POST EPC MEMORANDUM

RE: PR-2024-009765 SI 2023-00468 – Site Plan- EPC

SI-2023-00468 – Site Plan EPC, Major Amendment

ENGINEER'S SEAL RONALD R. BOHANNAN P.E. #7868	NOBIS REHAB HOSPITAL 1100 WOODWARD PL.	DRAWN BY pm
	SITE PLAN	DATE 2-26-24
	 5571 MIDWAY PARK PL. NE ALBUQUERQUE, NEW MEXICO 87109 (505) 858-3100 www.tierrawestllc.com	DRAWING 2023123-SP
		SHEET # SP-1 JOB # 2023123

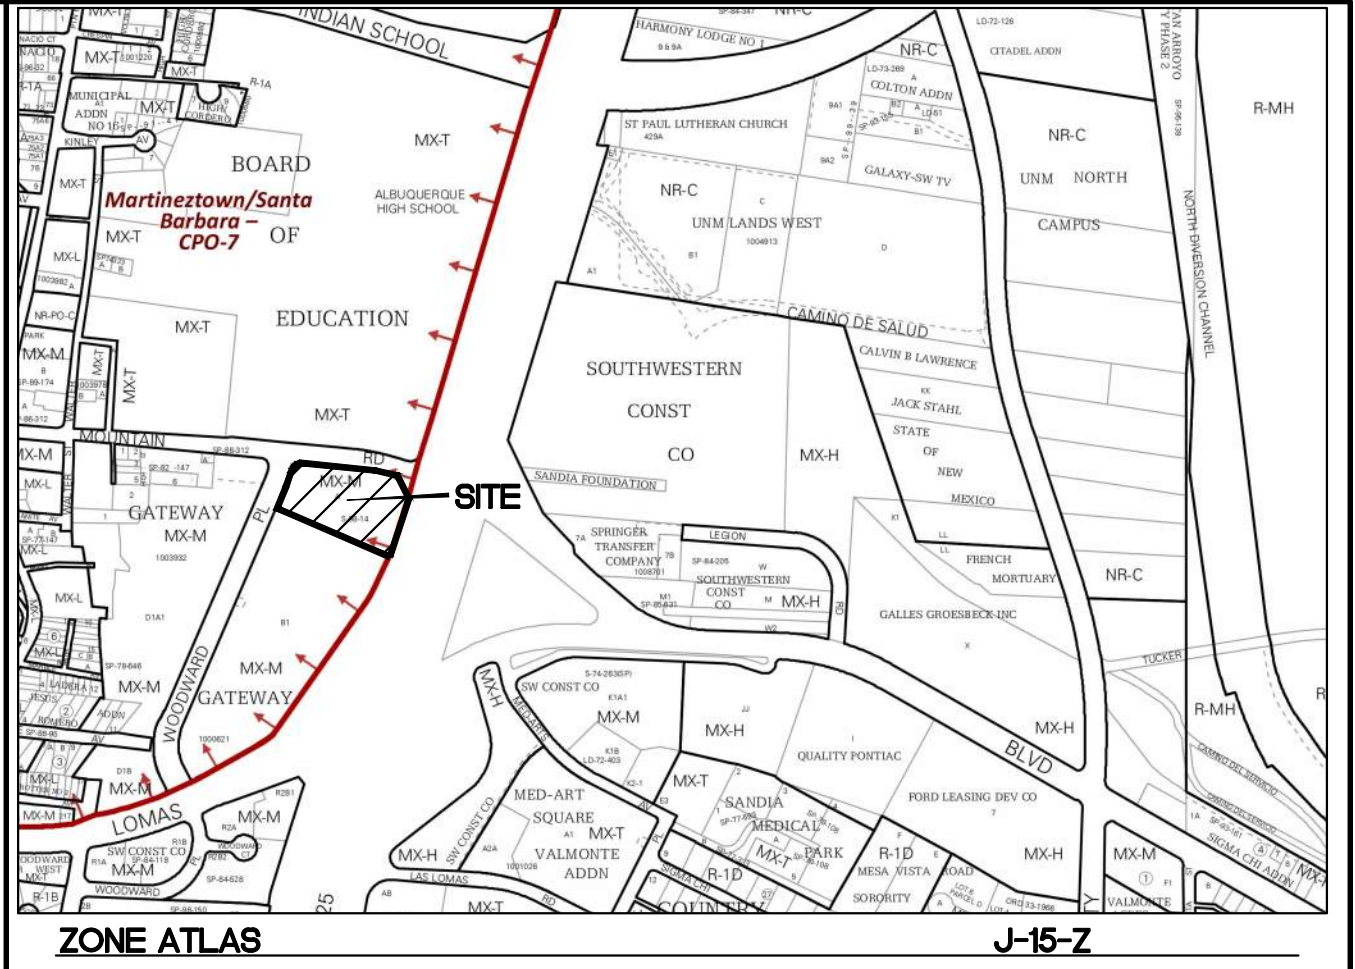
3. Condition 5. A: The applicant has added the work “minimum” to the Site Data table to confirm that minimum setbacks will be met, which meet the dimensions on the site plan.

4. Condition 5.B: 160 parking spaces are now shown on the site data table, which meets this condition.
5. Condition 6. A. The applicant has provided callouts of square footage of landscaping provided in planting beds. The DFT reviewer shall check for accuracy.

10. Condition 10. A general note has been provided and easements are now shown.

12. A sidewalk is now shown and the condition is met.
